Objection to FG/51/20/HH.

I am aware that we are too late officially to comment on the Planning Application for 66 Elm Park, but would hope you can consider these points.

PROJECT	Groome, No.66	DRAWING NO.	1459-P004	SCALE	1:100 @ A3	02	A
ADDRESS	No.66 The Cottage Elm Park Ferring	DRAWING TITLE	Proposed Ground, First & Roof Plans	DRAWN BY	CRE8TIVE LINES - ROZ NOWAK	May	2020
ARUN DISTRICT COUNCIL FG/51/20/HH BN12 5RW

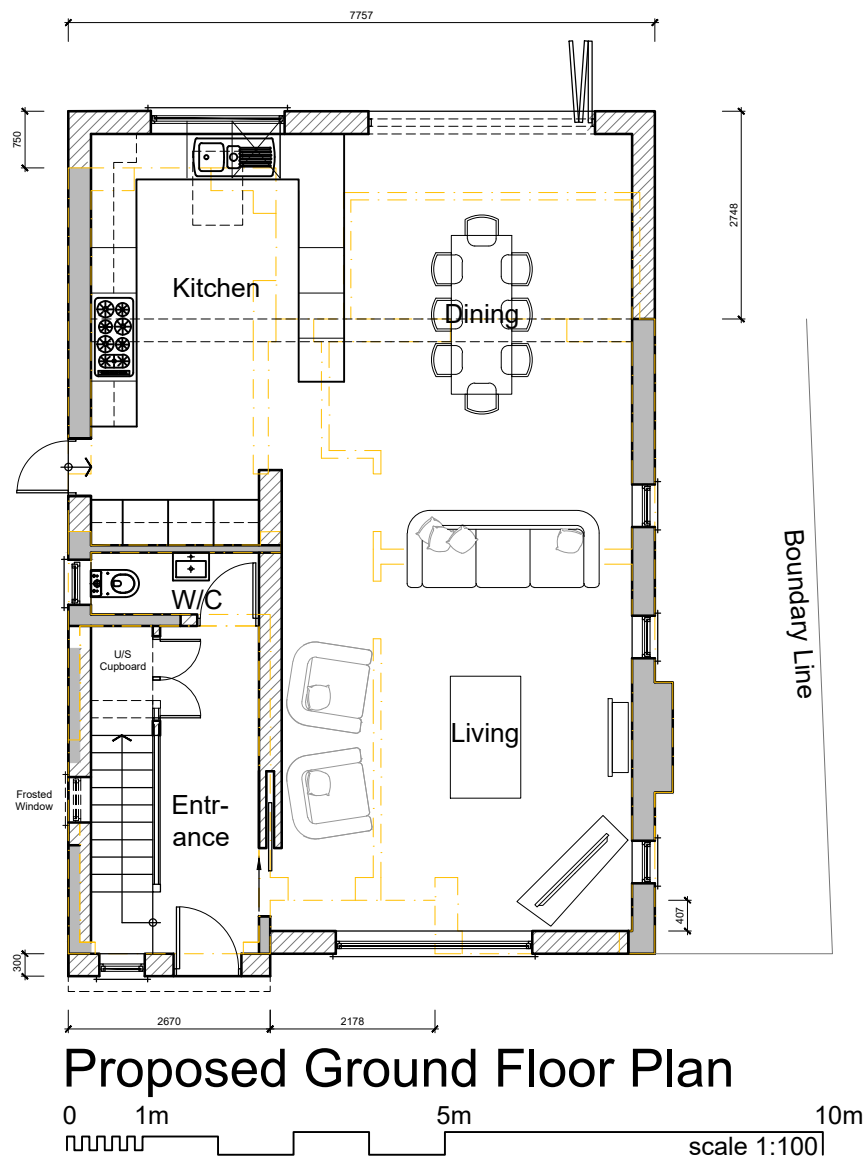
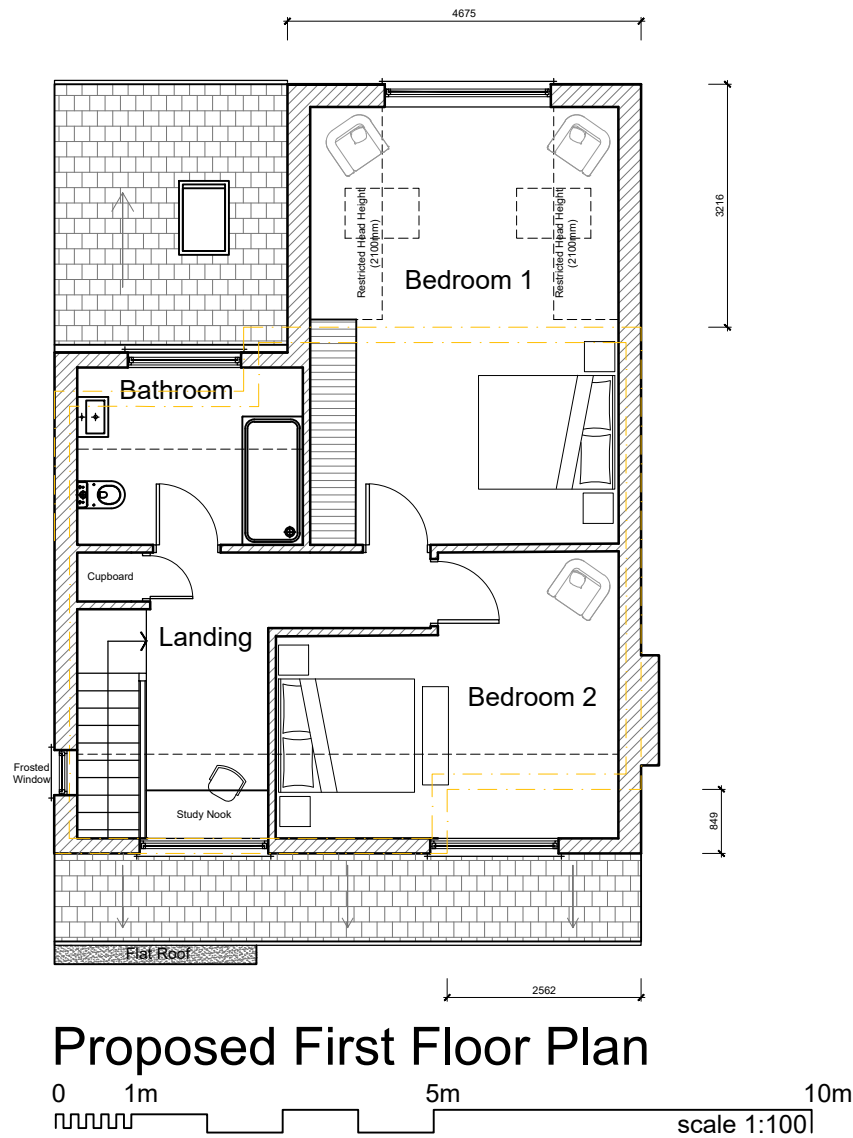
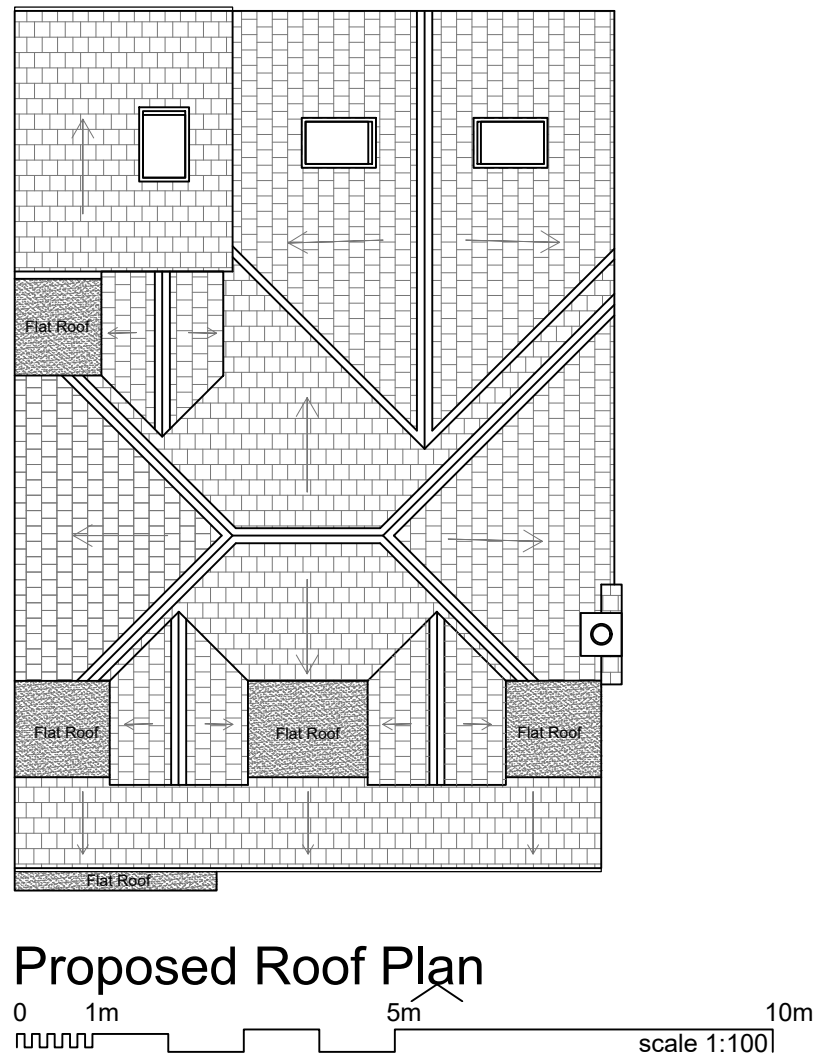
We live at 60 Elm Park and we have some concerns that the increase in number at the back of 66 would mean our garden and property would be more overlooked than at the moment.

DRAWING TITLE Proposed North & East Elevations

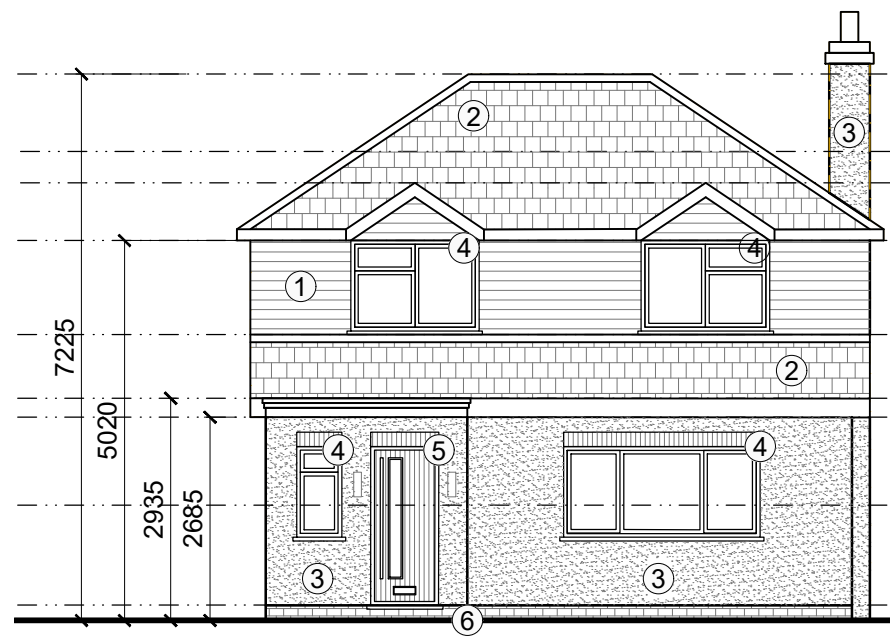
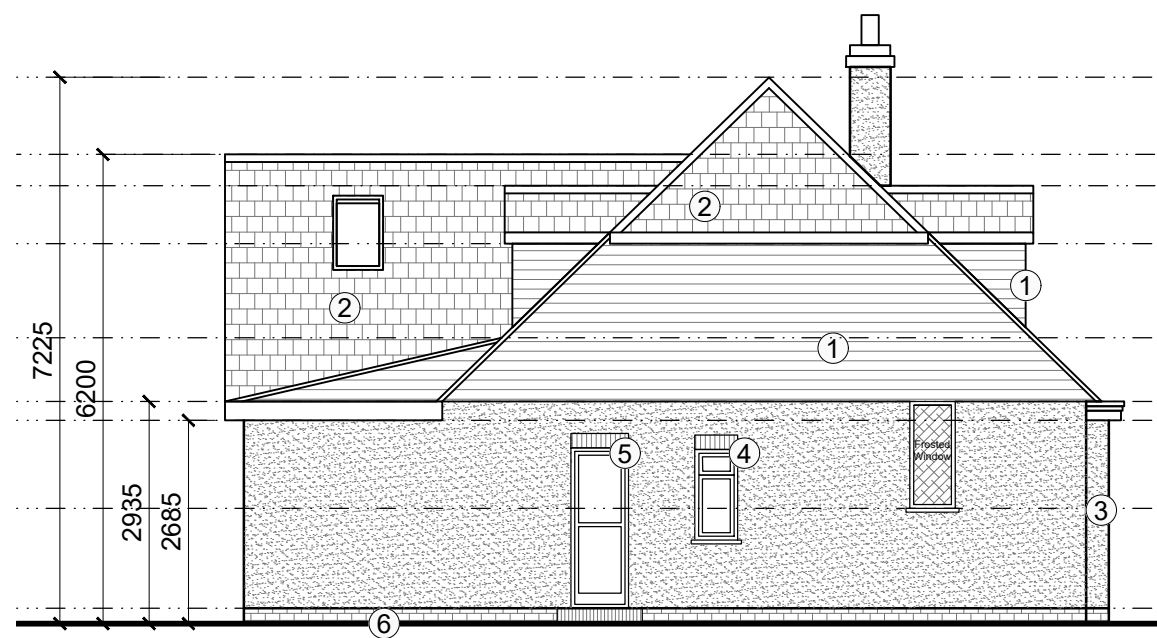
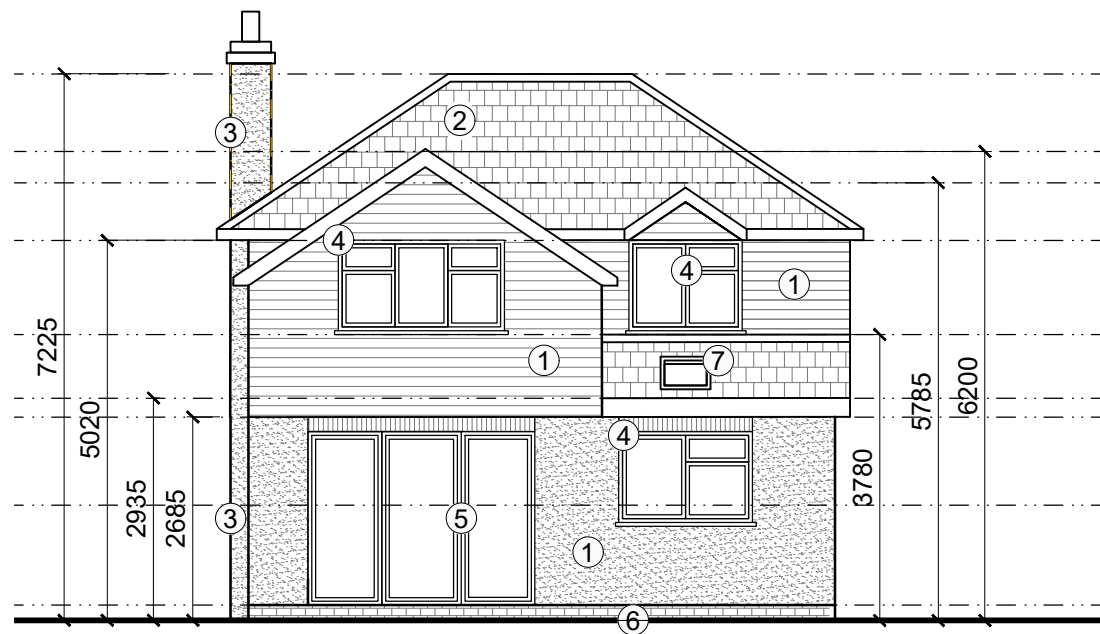
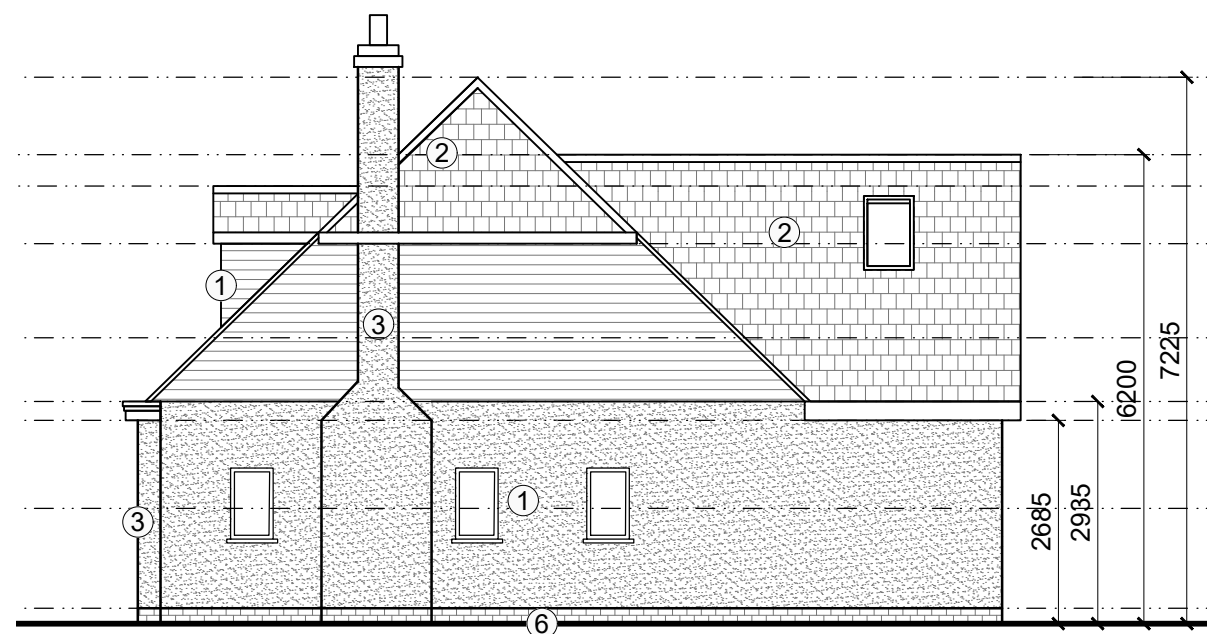
The drawings show a considerable change to 66 Elm Park, all the other houses are dormer style bungalows, looking at the plans 66 would become a two story house which is not in keeping with Elm Park.
